CITY OF ALBUQUERQUE

July 3, 2019

Re: Country Club Plaza Ph 3, 1716 Central Ave SW
Request for Conditional Certificate of Occupancy - approved
Certification dated: 7-2-19

PUMP DETAIL
SCALE: NONE

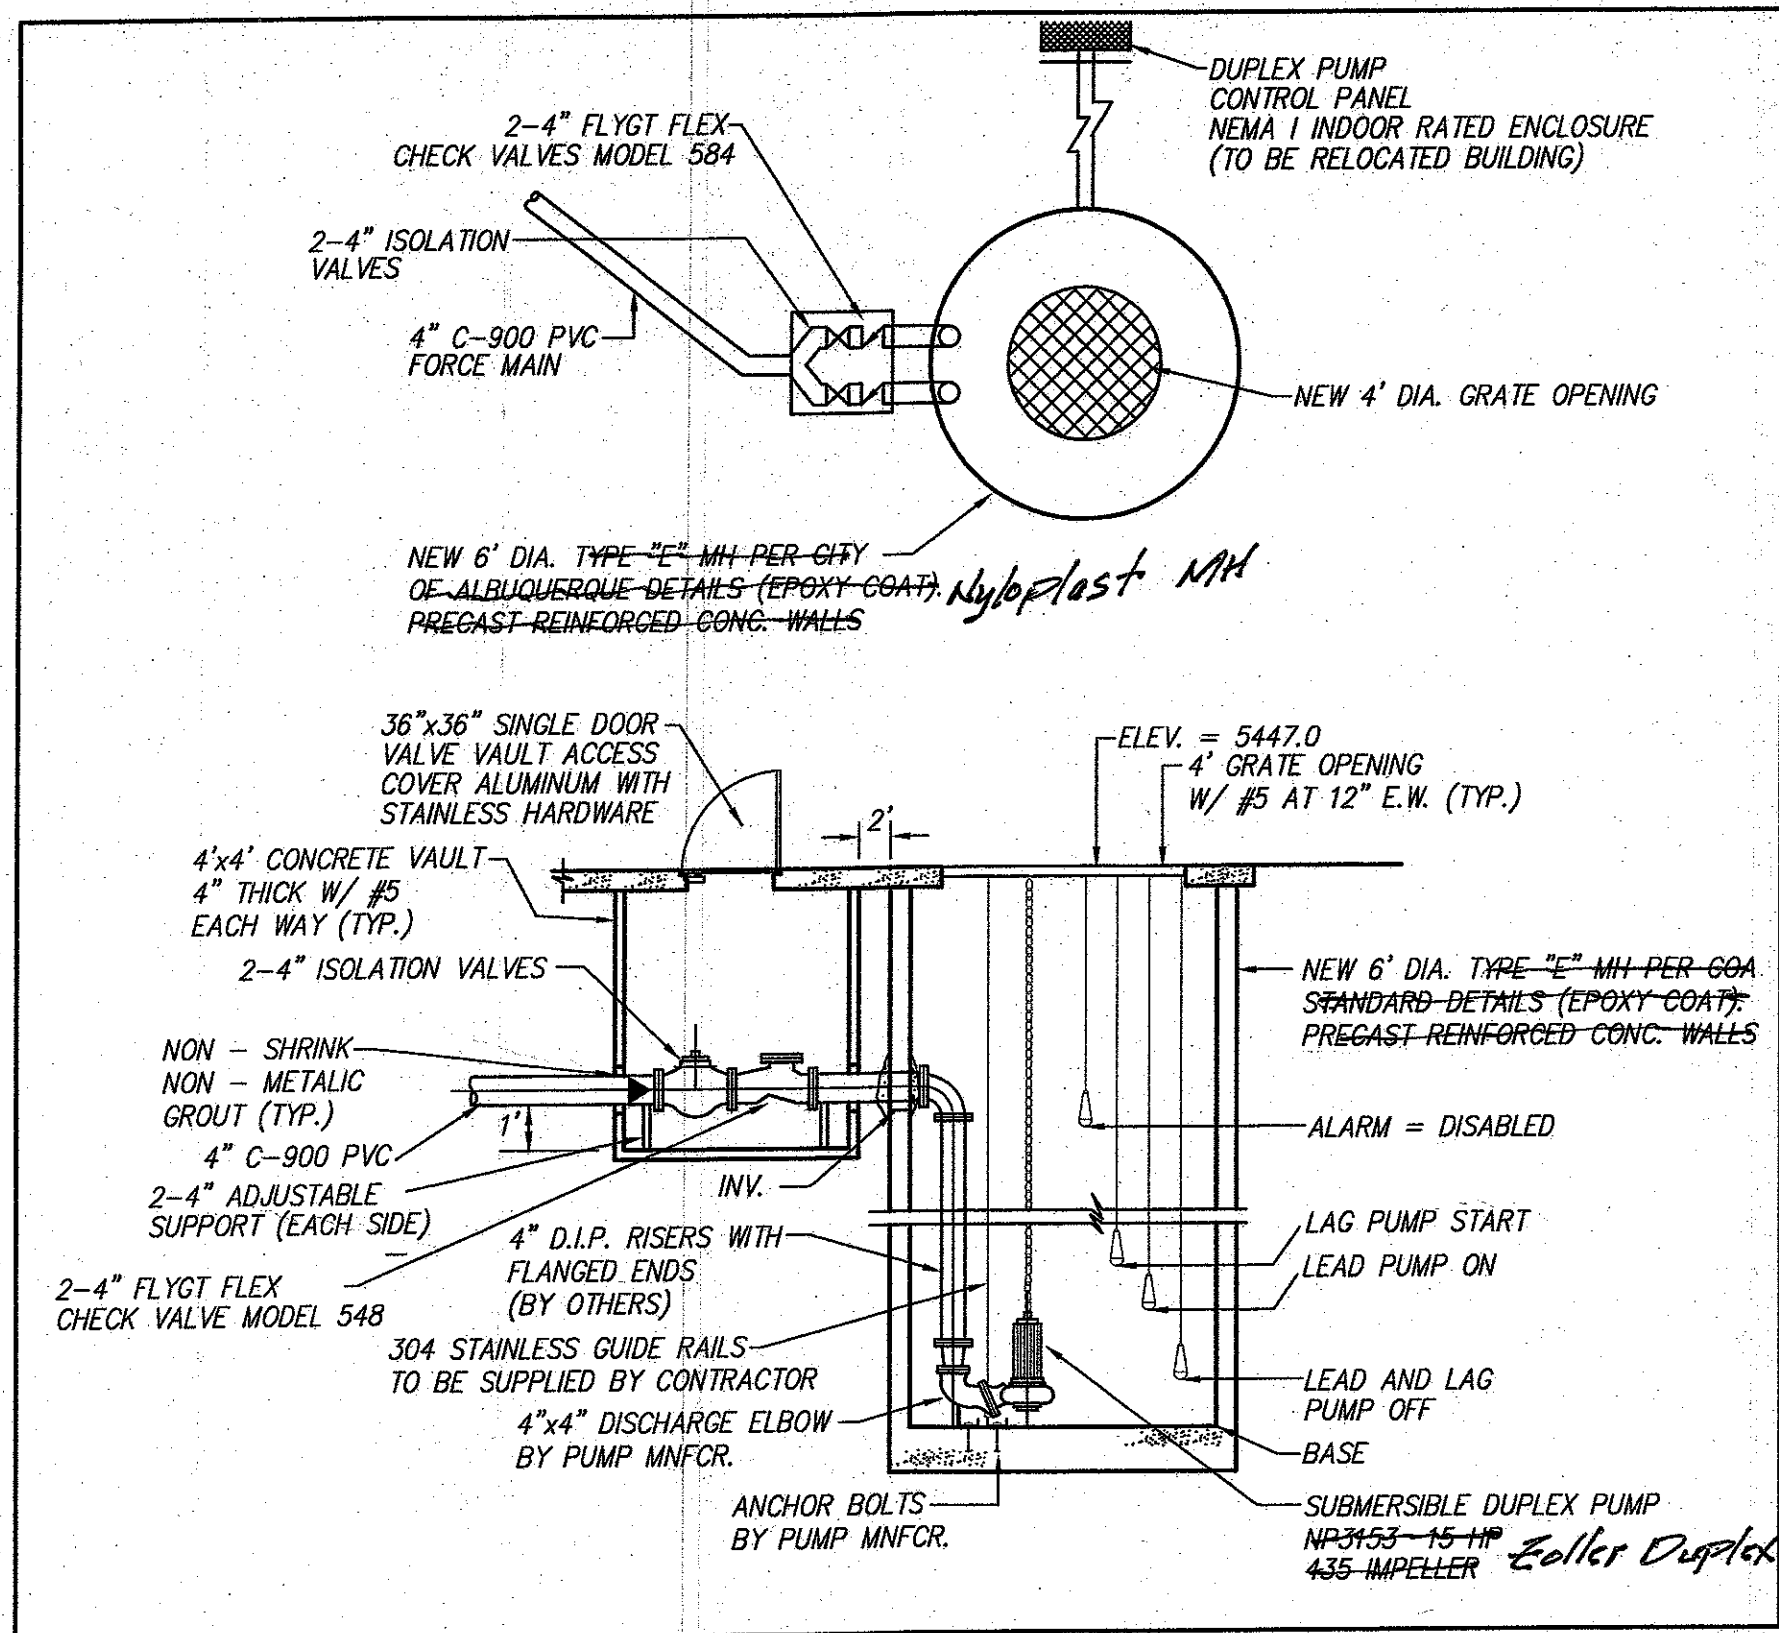
1. The sidewalk culverts are a complete remove and replace. Construct per City Detail 2236; the drain line should also be constructed similar to City Detail 2235 (see attached). Once complete, contact Rita Harmon for re-inspection or any questions (328-3221, rharmon@cabq.gov)
2. Raise pump control panel above top of retaining wall in Pond 2.
3. Excavate 1-2 courses of CMU and apply asphalt emulsion damp-proofing to elevation 53' around detention Pond 1
